PROJECT: Colorado Springs My Place Hotel

DATE: November 1, 2017

LDG ADDENDUM NO.: C

CITY COMMENTS & RESPONSES:

SITE DEVELOPMENT PLAN

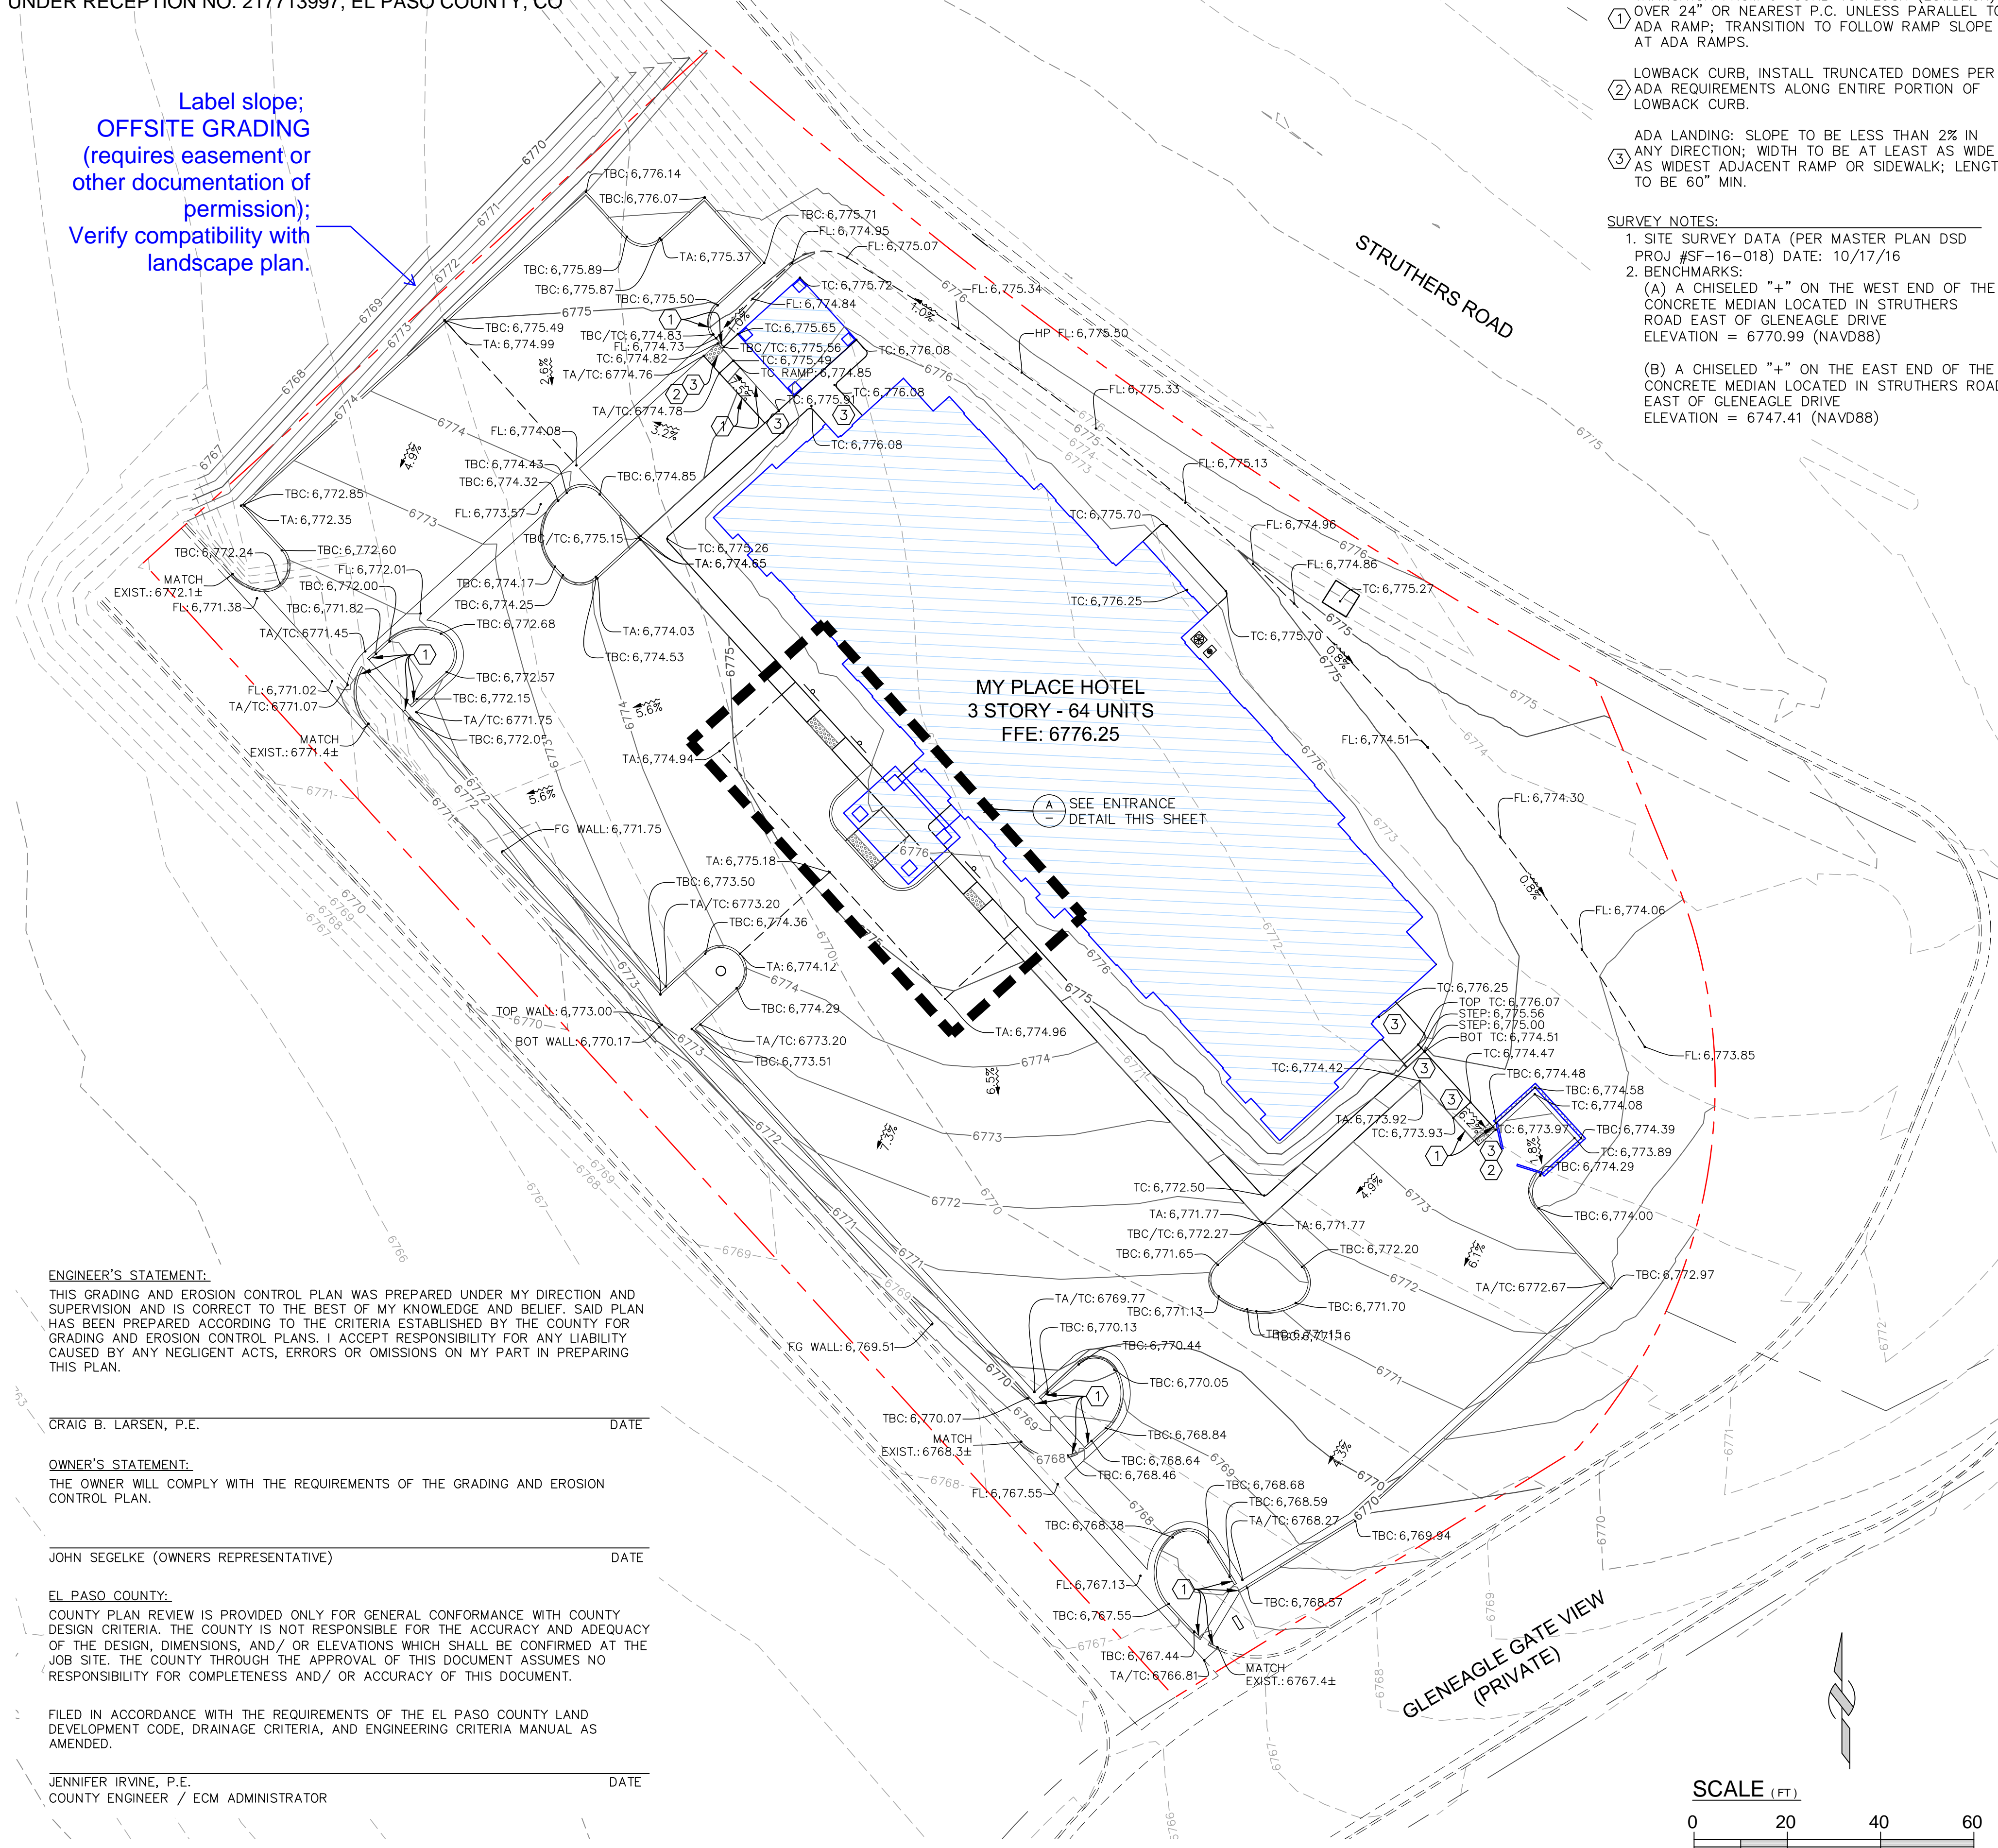
- Delete Jeff Rice's name from sheet C000
 - Deleted
- Verify Black Hills Energy is not the gas provider.
 - Verified, the City of Colorado Springs will provide natural gas service.
- Partially resolved; see updated redlines regarding compatibility of landscaping and 2:1 slope on the northwest side of the site.
 - Slopes are revised to be 3:1 max at all areas of the project. The northwest side of the site will require permission from the adjacent landowner, James Barash, and is included with this submittal.

- GECP checklist items 17, 20 and 21 need to be completed. If offsite grading is proposed an easement or other documented permission to grade is required.

- (17) Any offsite grading clearly shown and called out: Offsite grading is shown on C300 along the NW property line. Permission to perform this grading has been acquired from Mr. James Barash and is included with this submittal.

- (20) Proposed slopes steeper than 3:1 with top and toe of slope delineated: All slopes have been revised to be 3:1 or flatter.
 - (21) Erosion control blanketing shown on slopes steeper than 3:1: All slopes have been revised to be 3:1 or flatter making erosion control blanketing unnecessary.

EROSION CONTROL PLAN C400

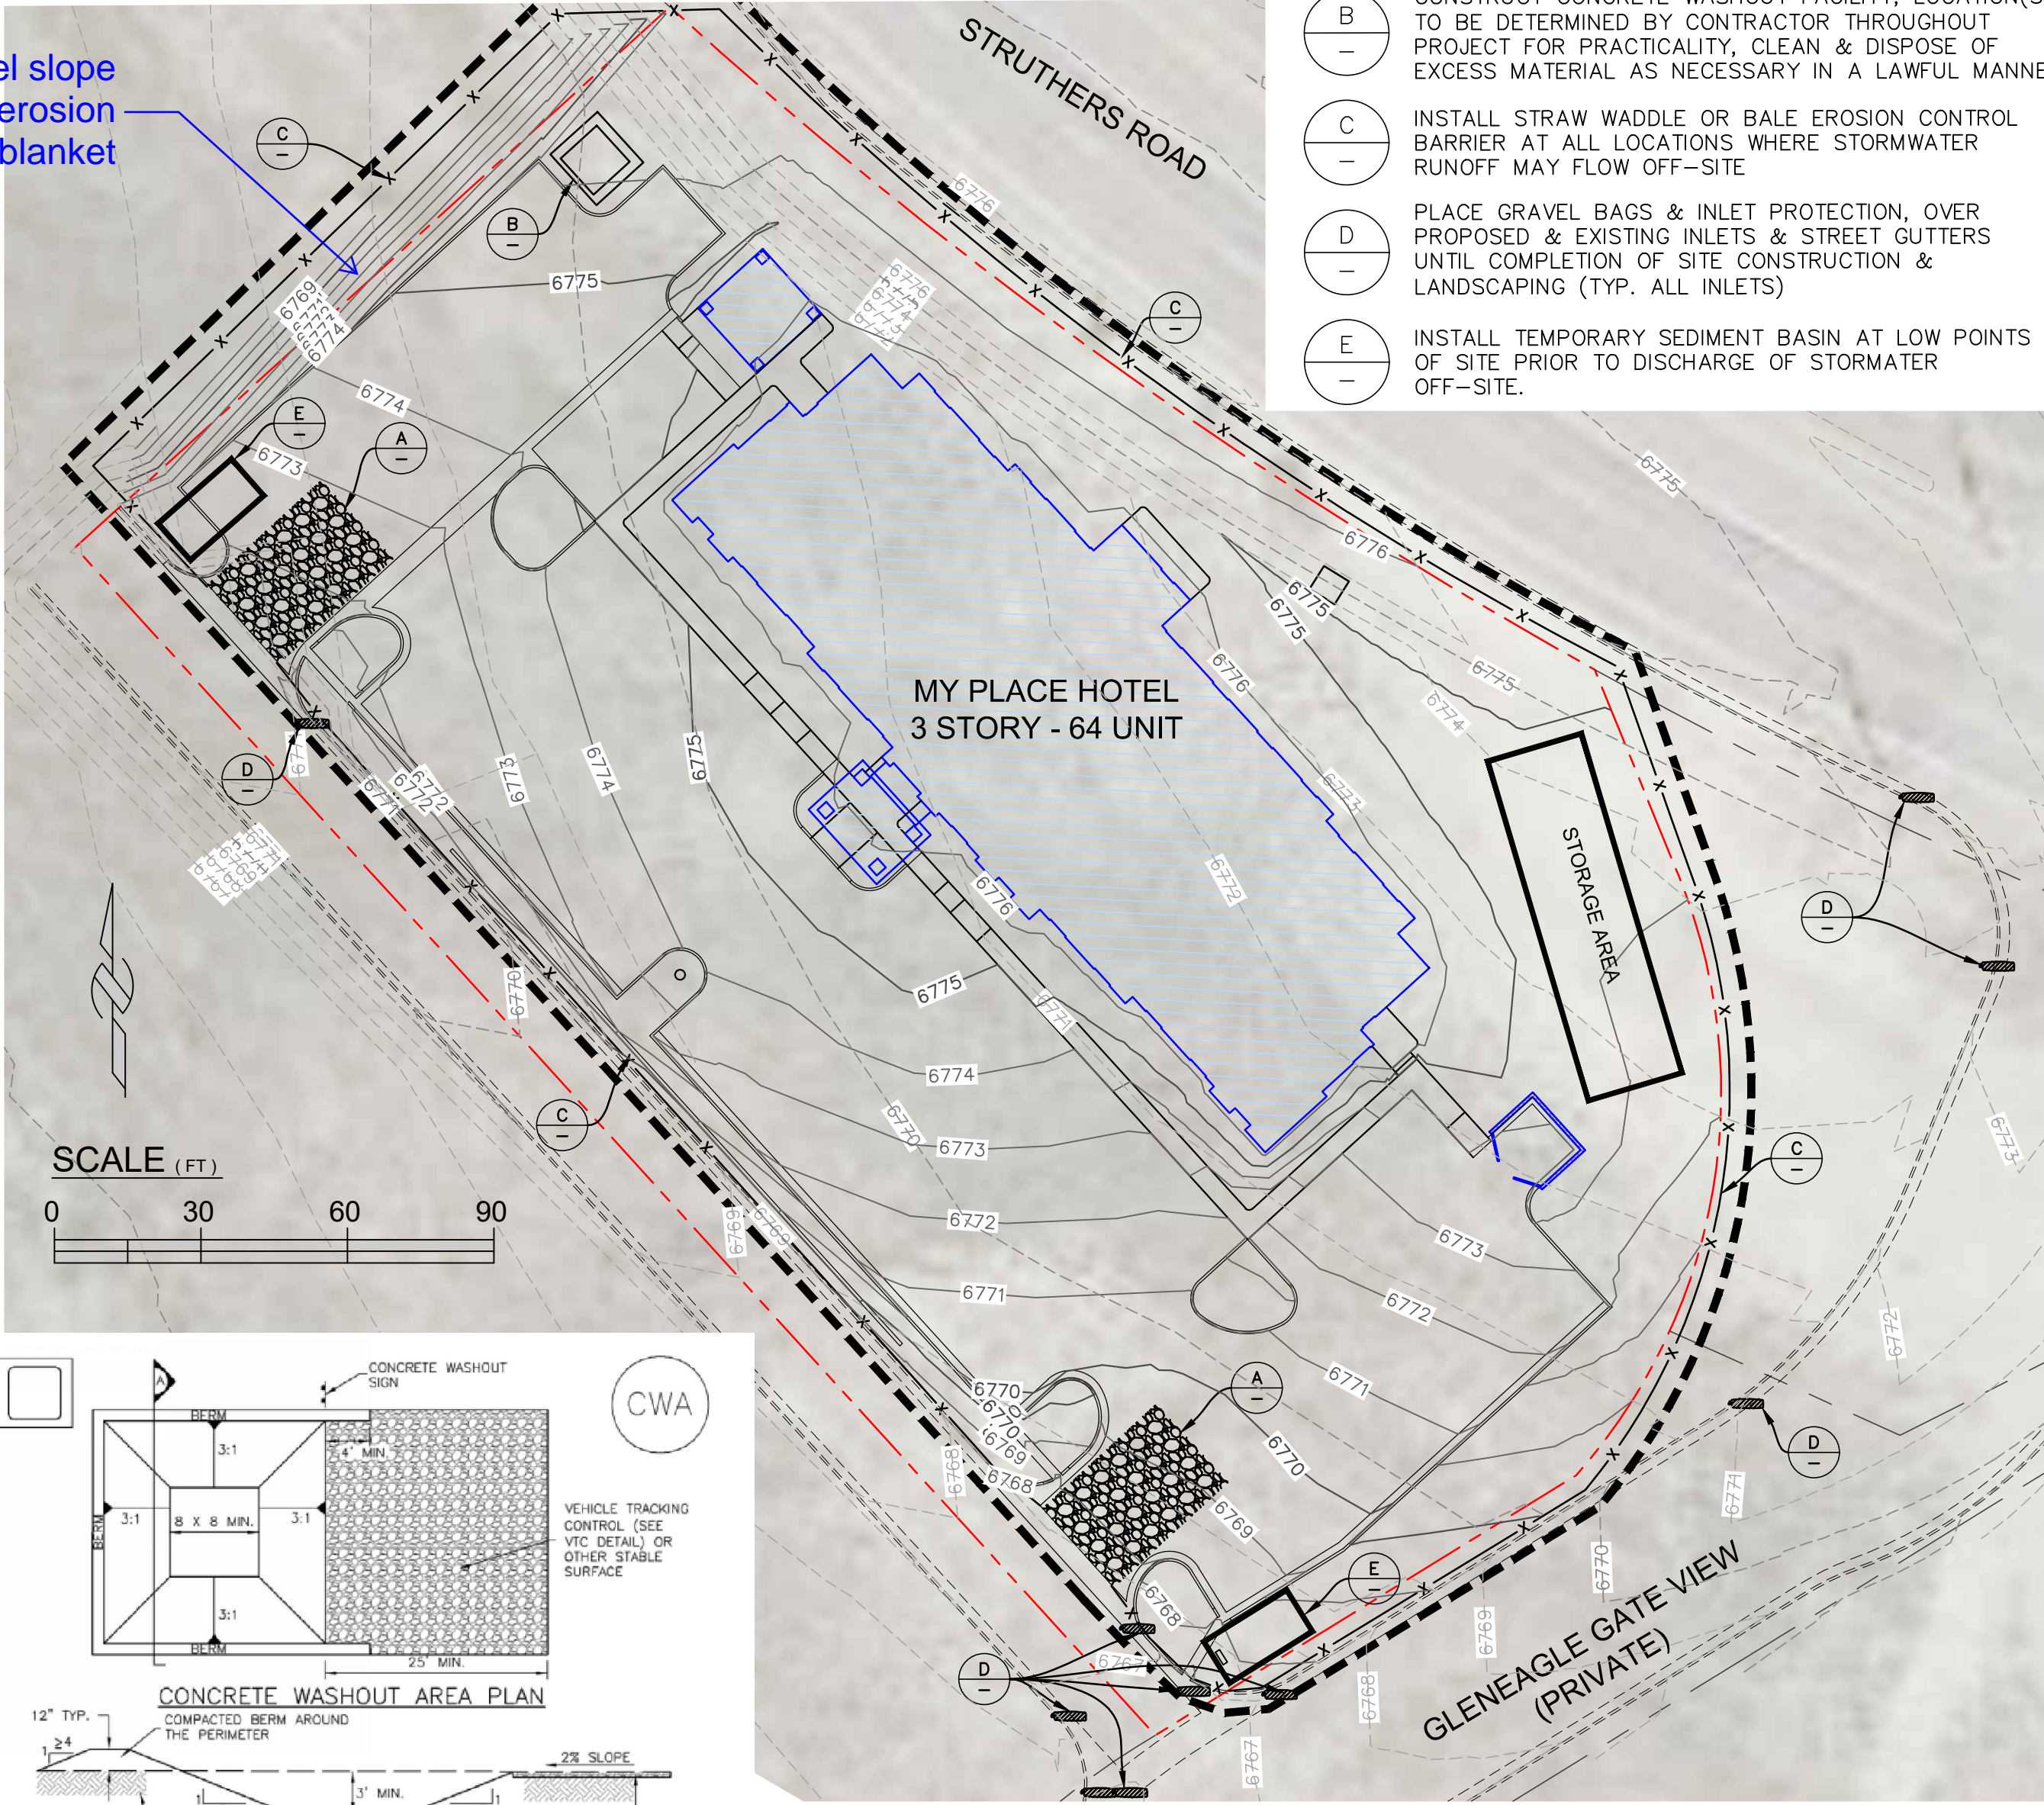
- Verify that SWMP checklist items 8 and 19 are complete (provide ECB detail).
 - (8) Soil erosion potential and potential impacts upon discharge
 - (19) Technical drawing details for BMP installation and maintenance

- Some checklist items including 5, 10 and 16 may need to be updated by the contractor onsite.
 - (5) Phasing plan – may require separate drawings indicating initial, interim, and final site phases for larger projects. Provide “living maps” that can be revised in the field as conditions dictate: Phasing is not anticipated. In the case this condition changes a note has been added to C400 to deal with the situation.

- (10) The location and description of any other potential pollution sources such as fueling (mobile or stationary), chemical storage, etc.: on-site storage of these items are not anticipated. In the case this condition changes a note has been added to C400 to deal with the situation.
